**RE: MDS – Montage Subdivision Unit 7 on Bobby Foster
Grading and Drainage Submittal for Preliminary Plat and Grading Permit
Engineer's Stamp Date: 6/30/22
Hydrology File: R16D100A**

We are requesting approval of the construction plans for Montage Subdivision Unit 7. The construction plans have been revised according to comments received from City of Rio Rancho.

Below is a list of comments received on October 5, which are included in *italics* and our responses in **bold** text.

GRADING COMPOSITE

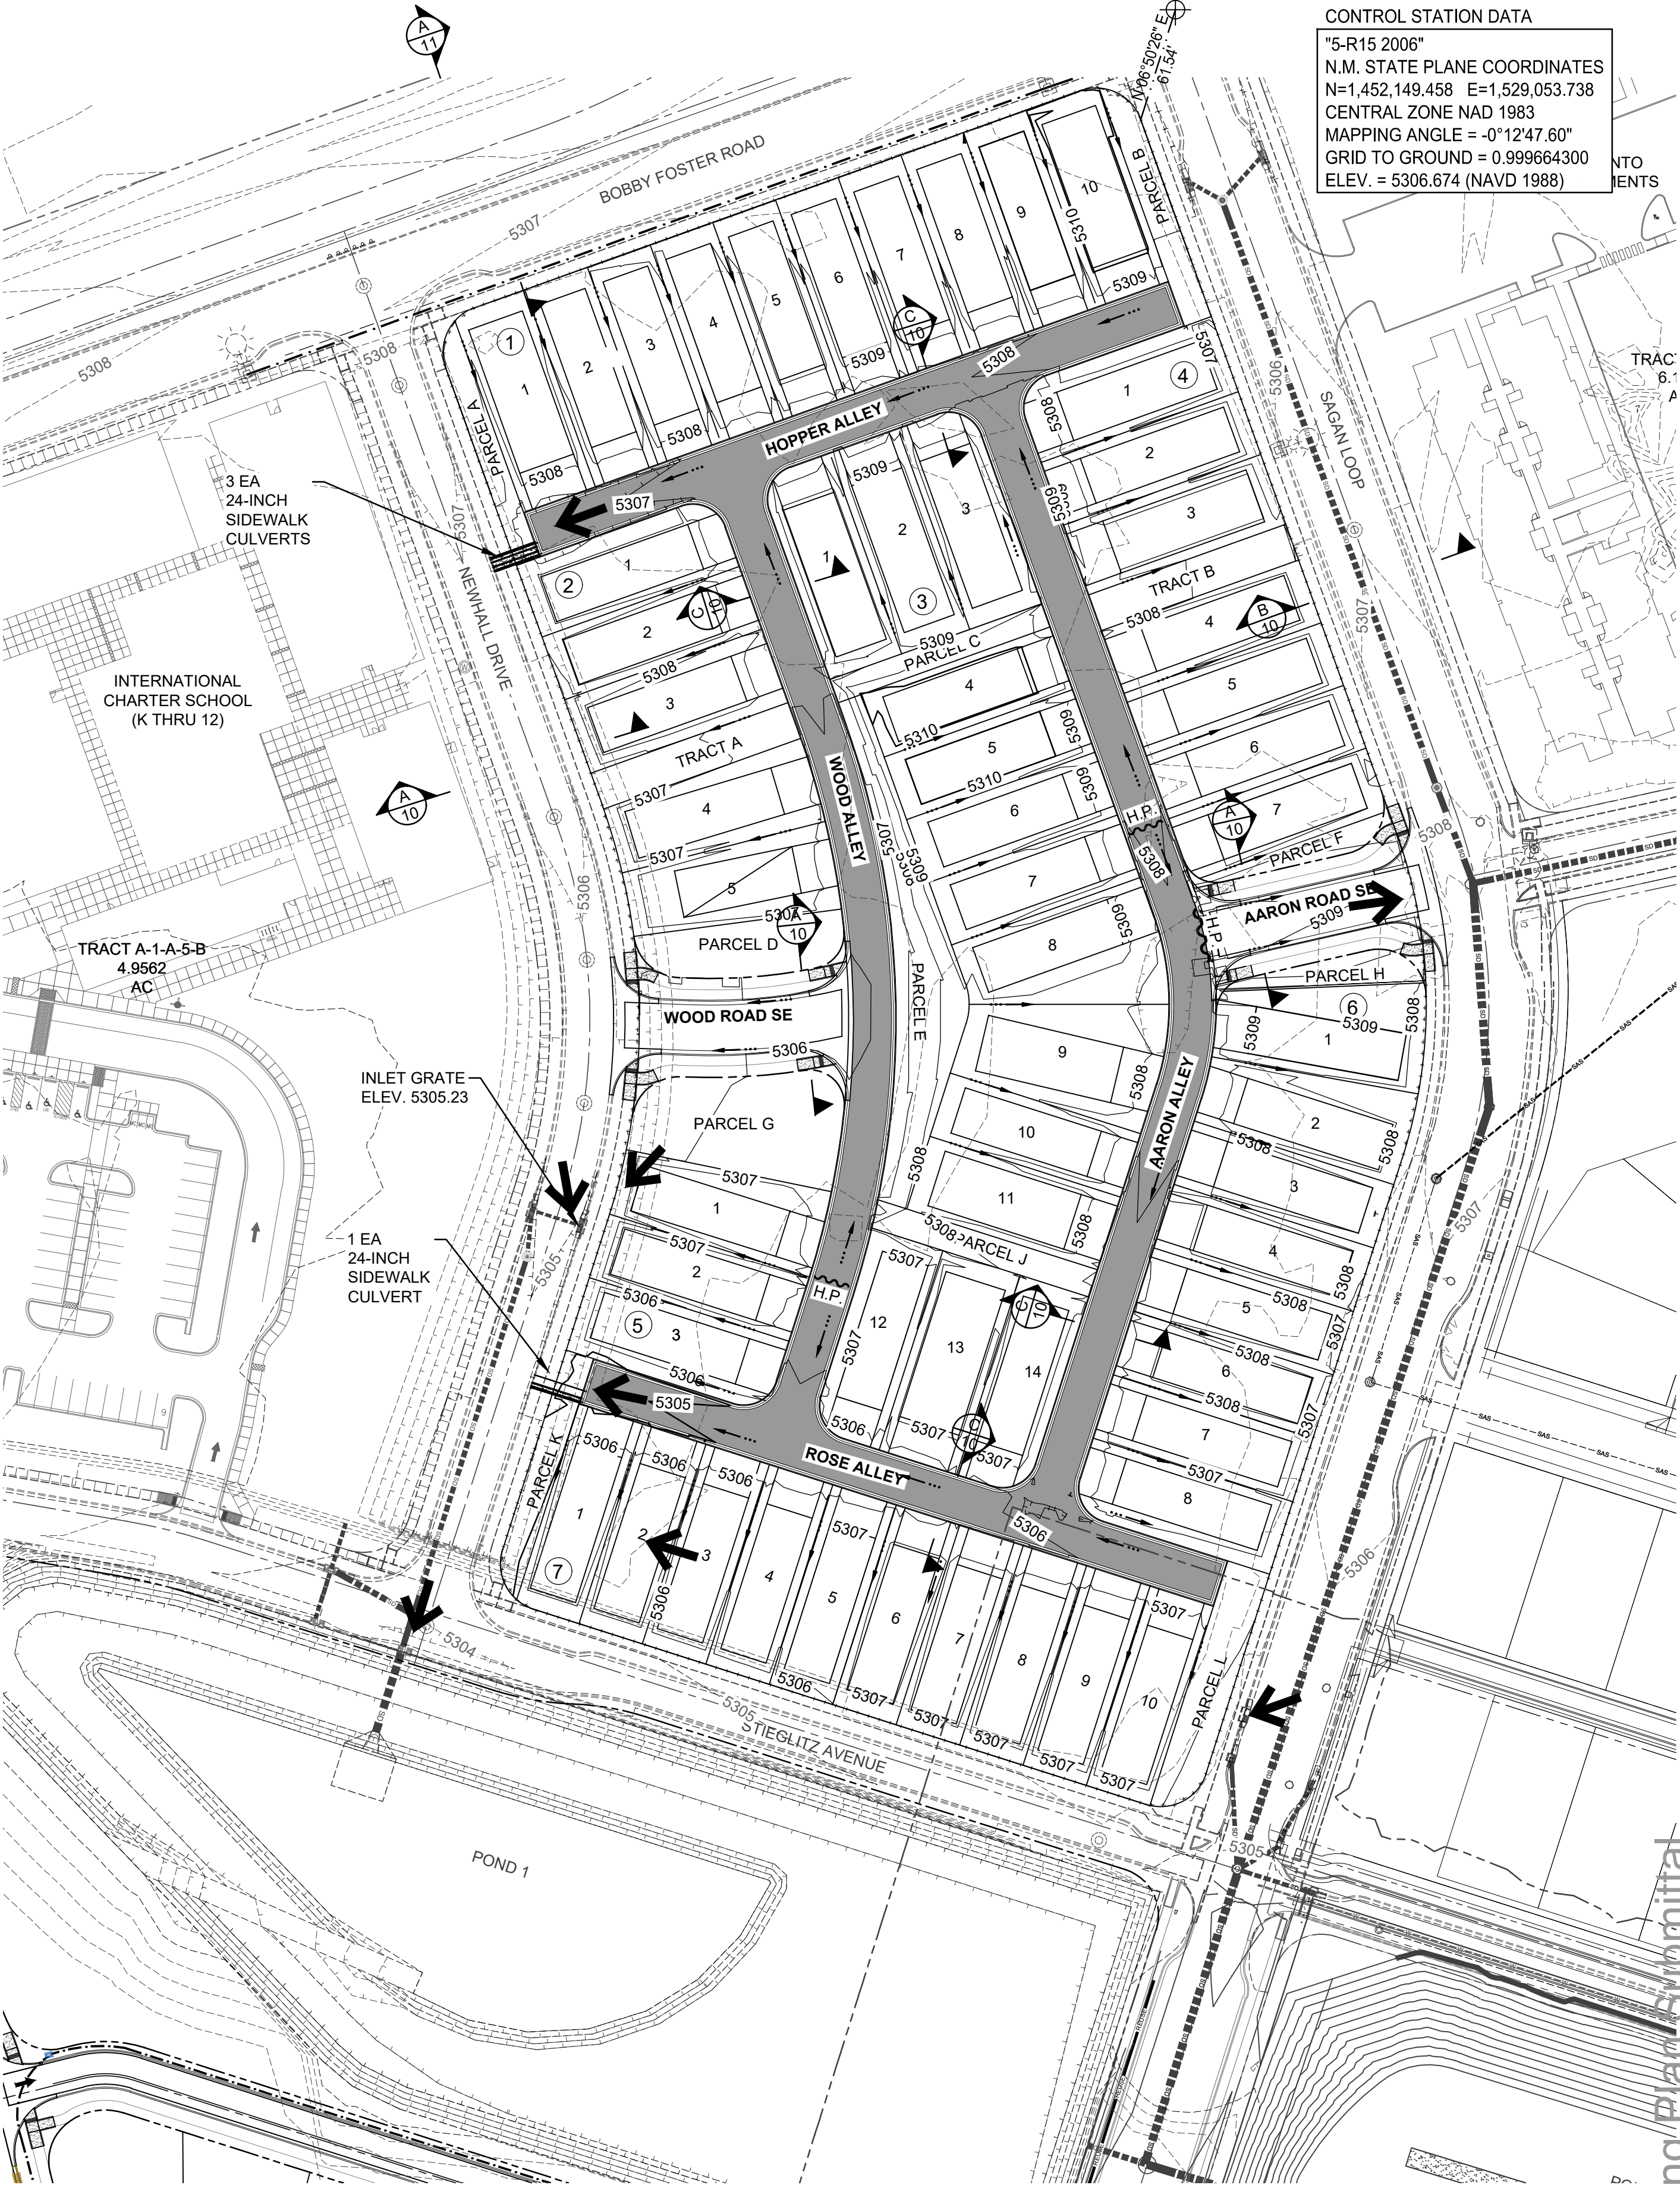
1. *The drainage report that provided onsite hydrology analysis splitting the site into two large basins requires more data. More detailed sub-basin analysis will be required prior to approval of the infrastructure list (IL) and preliminary plat (PP).*
The basin map has been updated and split into 5 different basins. This will allow for adequate data for proper analysis. All basins will surface drain to Newhall Dr. Basins 100, 200, 300, and 400 will enter the storm drain as it leaves the subdivision. Basin 500 will surface drain and continue down Newhall Dr. until it enters Pond 1.

3. *The analysis of Bobby Foster project, hydrology #R16D100 must be updated to reflect the as-built condition where most of Basin "BF" drains down Diebenkorn Dr. and Newhall Dr. to "Pond 1" instead of draining down Sagan Lp. To "Pond 2A" as planned in the original drainage report for Bobby Foster, hydrology file #R16D100. The drainage design and infrastructure for Montage Subdivision Unit 7 is highly dependent on the Bobby Foster Subdivision, so the stormwater quality volume (SWQV) calculations for the areas draining to "Pond 1" must be tabulated and the "Pond 1" volume and outfall hydraulic calculations must be added. The AHYMO file shows 2 acre-feet retention below elevation 5300 and says the outfall structure is an 18" pipe but doesn't provide volume and hydraulic calculations. They must be provided along with a detail of the outfall structure. The outfall structure was omitted from the WO plans but that condition isn't modeled in AHYMO. This analysis must be updated and approved prior to review of this Grading and Drainage Plan.*

The runoff from Bobby Foster has been added to Newhall Dr. street capacity and analyzed together with the proposed subdivision Montage 7. Pond 1 remains the outfall for the new subdivision with planned capacity to accommodate the proposed flow.

GRADING PLAN

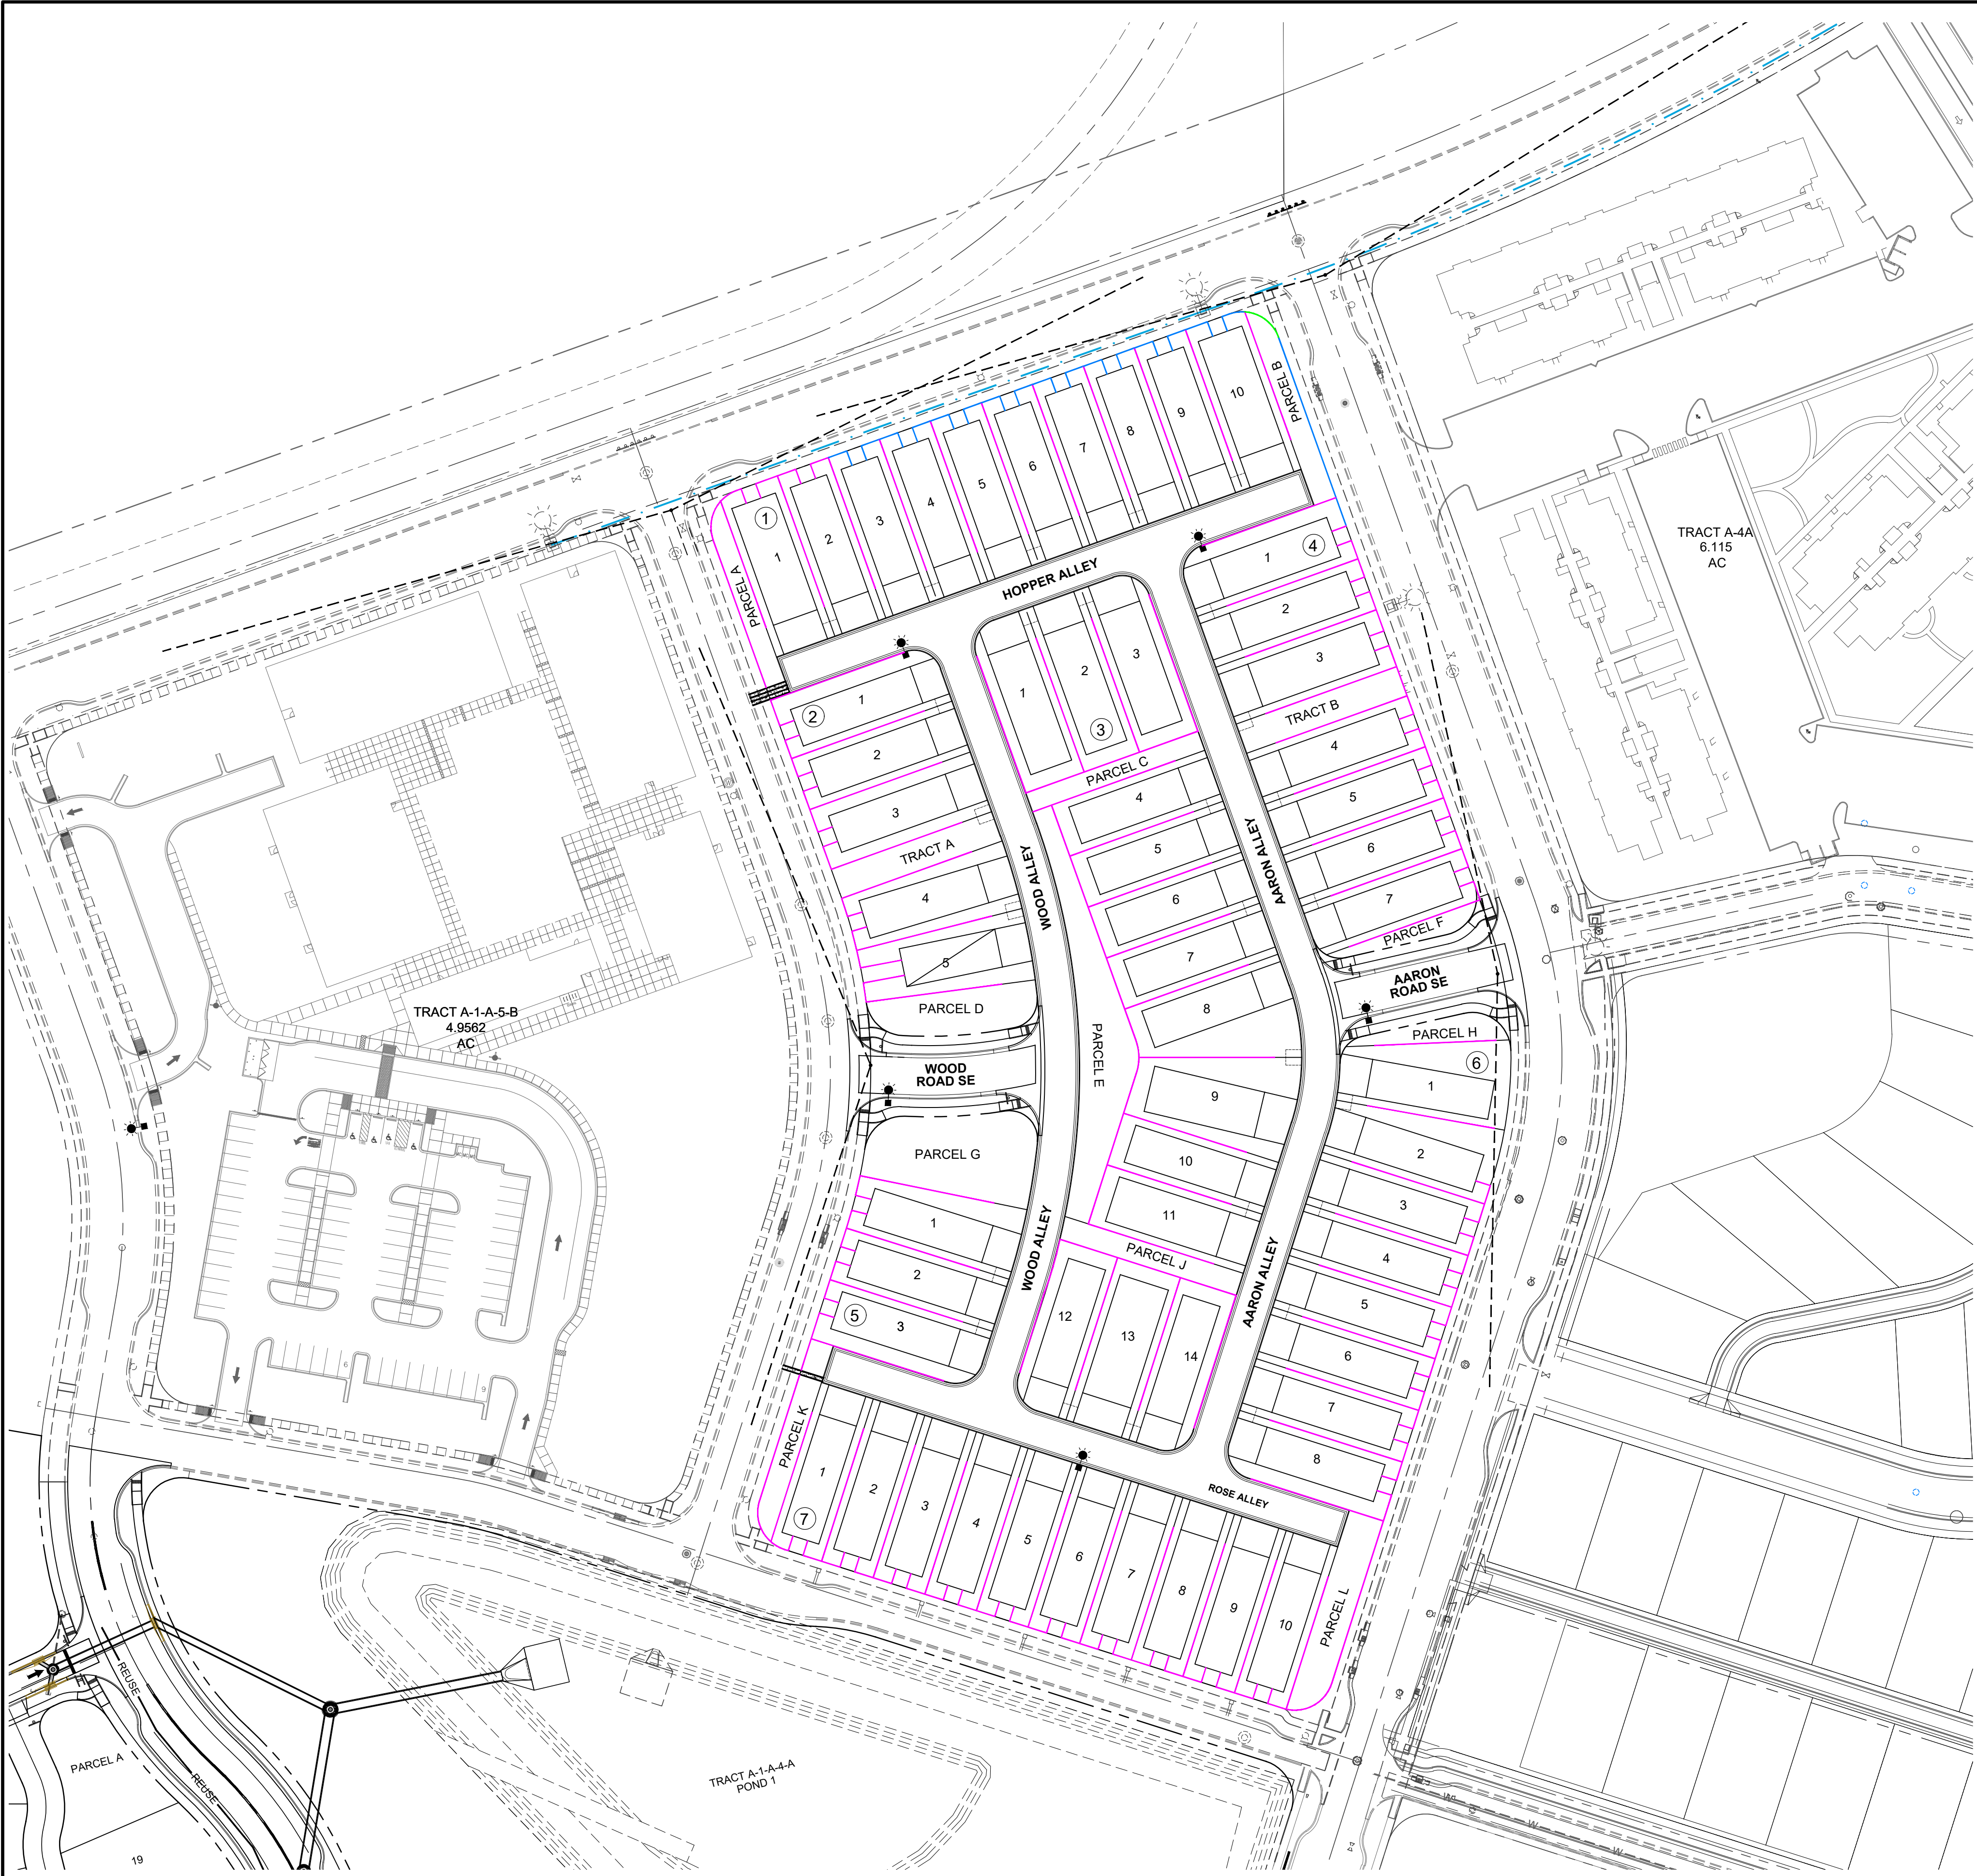
6. *Provide surface drainage analysis demonstrating that the 100-year HGL remains at/below top of curb, and the EGL remains within the ROW for the onsite streets and alleys and the adjacent streets that receive drainage from this site. The report has only one surface analysis (for 32' street 0.5% slope within 6" curbs, gutter depression is missing and location is missing). Identify the location of each analysis point and account for the effects of local gutter depression.*
Surface drainage analysis has been completed for all unique street sections associated with the proposed subdivision. Each onsite section falls within the allowable surface flow and Newhall Dr. will utilize the subsurface network to convey the runoff from specified locations of the subdivision.
